CITY OF ALBUQUERQUE

**Re: Discount Towing
109 Headingly
Traffic Circulation Layout
Engineer's/Architect's Stamp 4-7-16 (G15-D201)**

Based upon the information provided in your submittal received 4-21-16, the above referenced plan cannot be approved for Building Permit until the following comments are addressed:

B H.C. SIGN DETAIL
C1.1 1" = 1'-0"

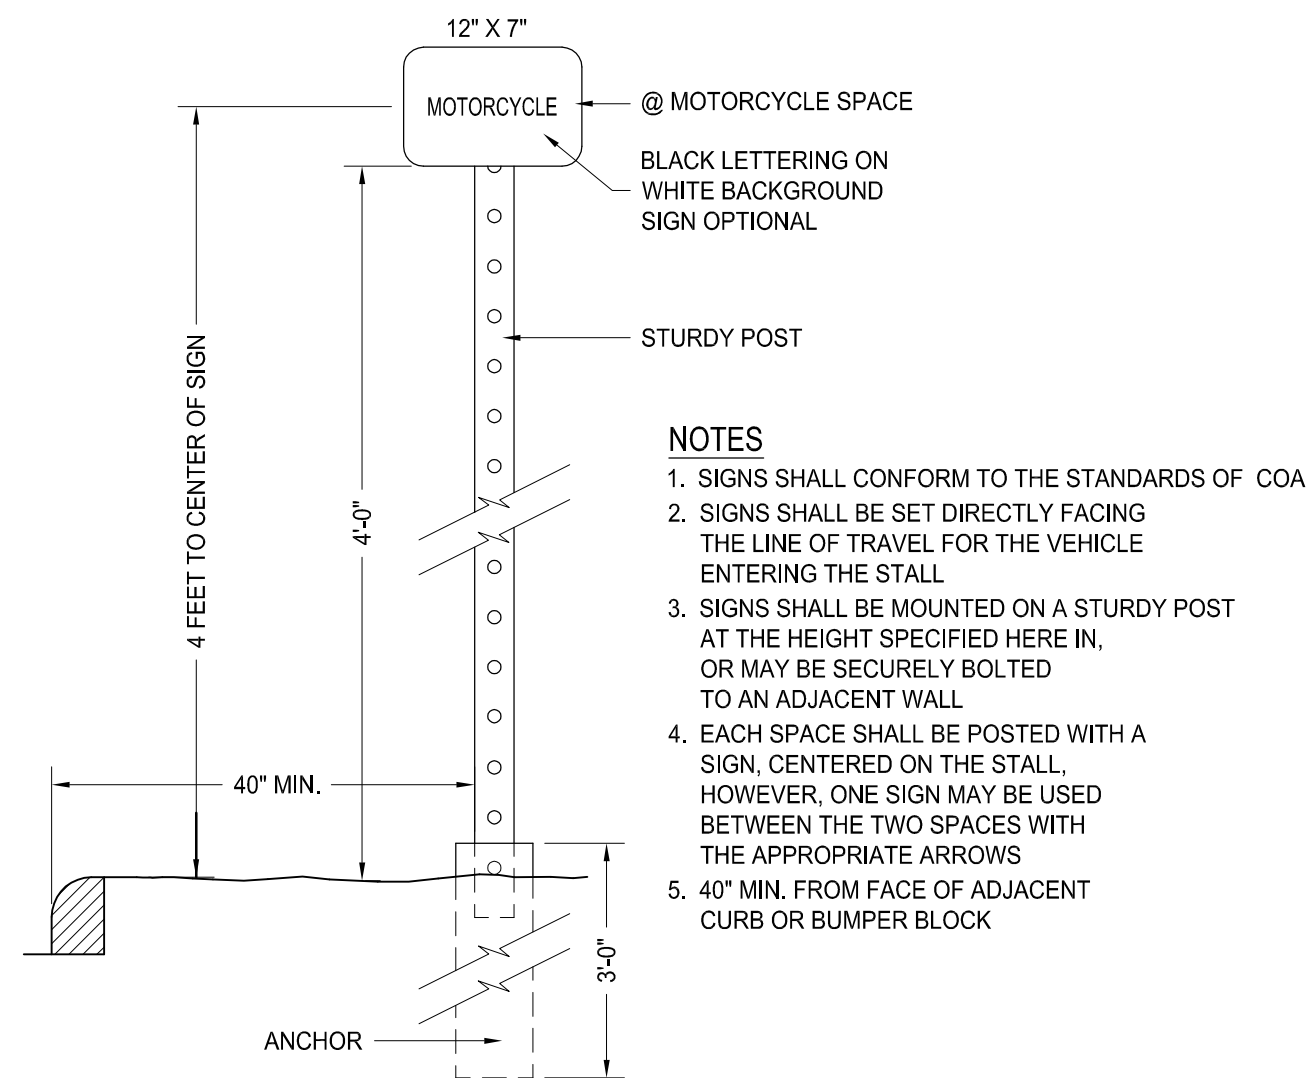
7. The handicap accessible spaces must include an 8 ft. wide van access aisle; all other aisles should be 5 ft. in width.
8. The ADA accessible parking sign must have the required language per 66-7-352.4C NMSA 1978 **"Violators Are Subject to a Fine and/or Towing."** Please call out detail and location of HC signs.

D H.C. STALL DETAIL
C1.1 1/2" = 1'-0"

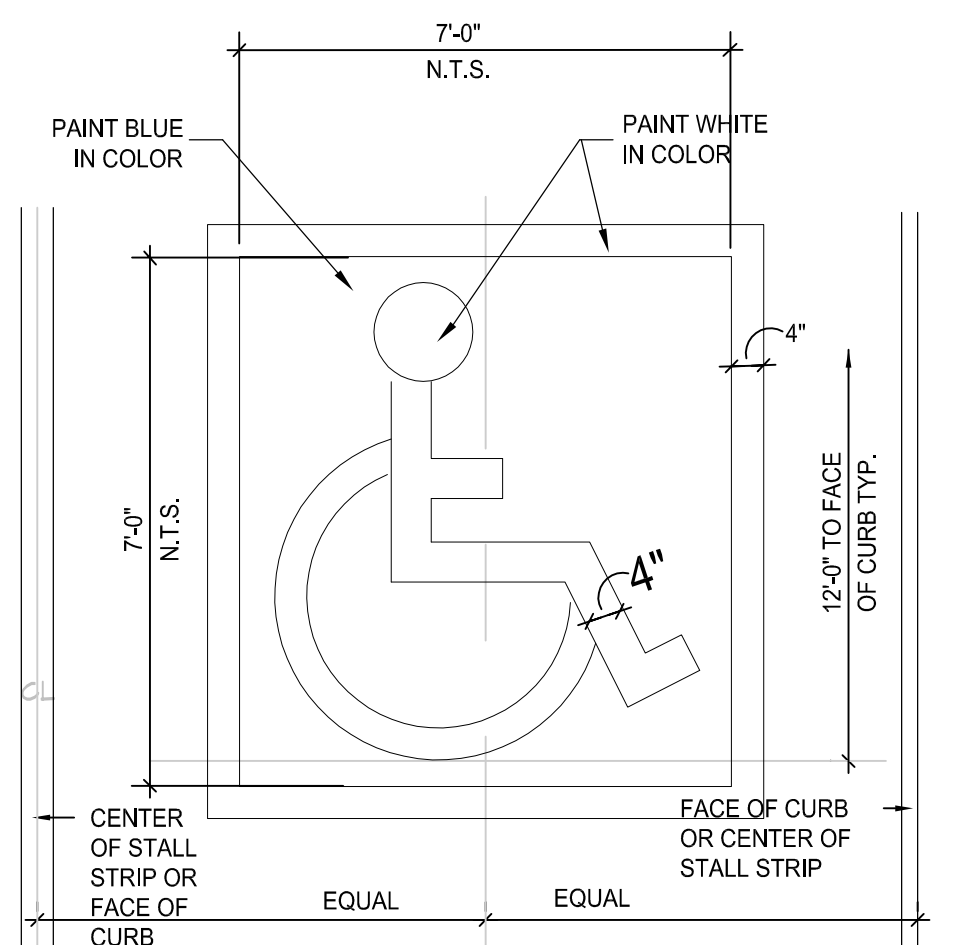
9. The ADA access aisles shall have the words **"NO PARKING"** in capital letters, each of which shall be at least one foot high and at least two inches wide, placed at the rear of the parking space so as to be close to where an adjacent vehicle's rear tire would be placed. (66-1-4.1.B NMSA 1978)

A SITE PLAN
C1.1 1" = 30'-0"

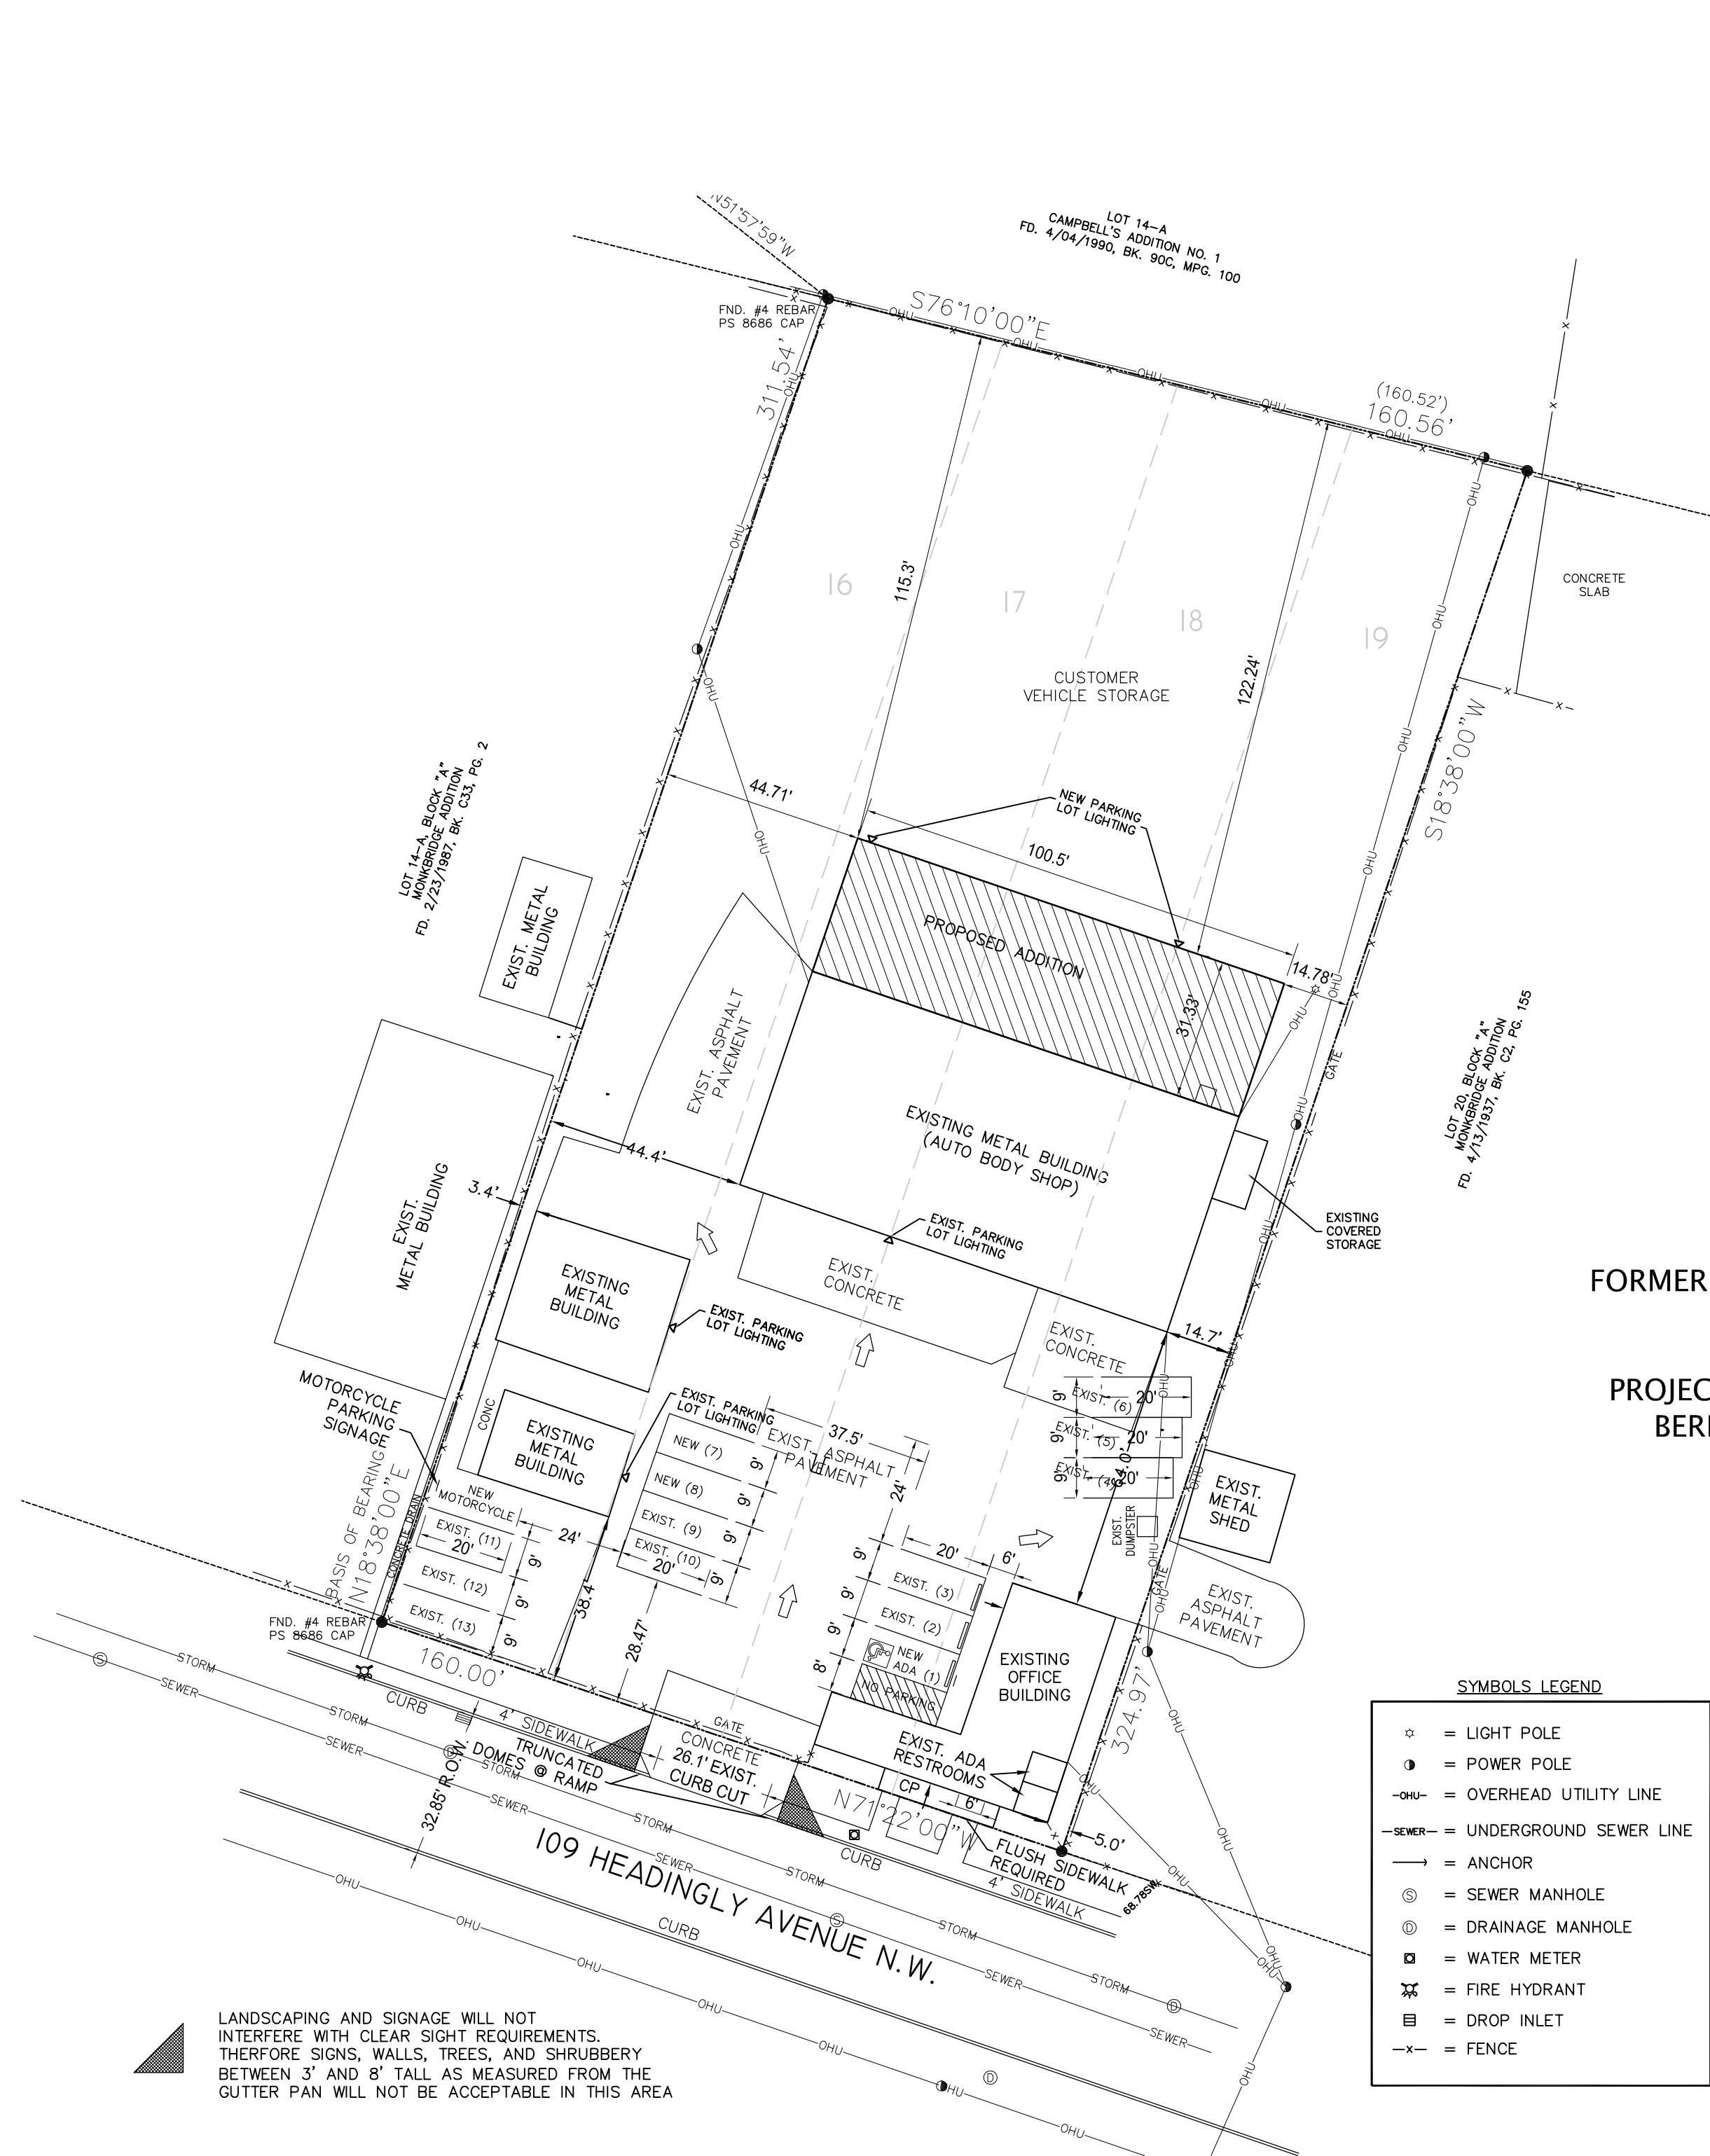
1. Please show a vicinity map showing the location of the development in relation to streets and well known landmarks.
2. Please identify all existing buildings, doors, structures, sidewalks, curbs, drive pads, wall and anything that influences the parking and circulation on the site.

3. Please detail and dimension all existing ADA ramps at drive isles.
4. Identify the right of way width, medians, curb cuts, and street widths on Headingly Ave.

5. Please list the width and length for all existing and proposed parking spaces.
6. There must be a minimal of 24 ft. between abutting parking spaces. In review of the submitted drawing, there is only 22 ft. between parking spaces at the west end existing parking spaces.

10. Show all drive aisle widths and radii.
11. Per DPM, a 6 ft. wide ADA accessible pedestrian pathway is required from the public sidewalk to the building entrances. Please clearly show this pathway and provide details and dimensions.

12. Per DPM, a 6 ft. wide ADA accessible pedestrian pathway is required from the HC parking stall access aisles to the building entrances. Please clearly show this pathway and provide details and dimensions.

13. Provide a min 6" or max 8" high concrete barrier curb or other acceptable barrier between landscaping and parking areas and/or drive aisles. Please call out detail and location of barrier curb.

14. Design delivery vehicle route needs to be shown.
15. Service vehicle and/or refuse vehicle maneuvering must be contained on-site; provide a copy of refuse approval.

16. Please provide a sight distance exhibit (see the *Development Process Manual, Chapter 23, Section 3*).
17. Please add the following note to the clear sight triangle: "Landscaping and signage will not interfere with clear sight requirements. Therefore, signs, walls, trees, and shrubbery between 3 and 8 feet tall (as measured from the gutter pan) will not be acceptable in this area."

18. Unused curb cuts must be replaced with sidewalk and curb & gutter. A build note must be provided referring to the appropriate City Standard drawing.

19. All broken or cracked sidewalk must be replaced with sidewalk and curb & gutter. A build note must be provided referring to the appropriate City Standard drawing.
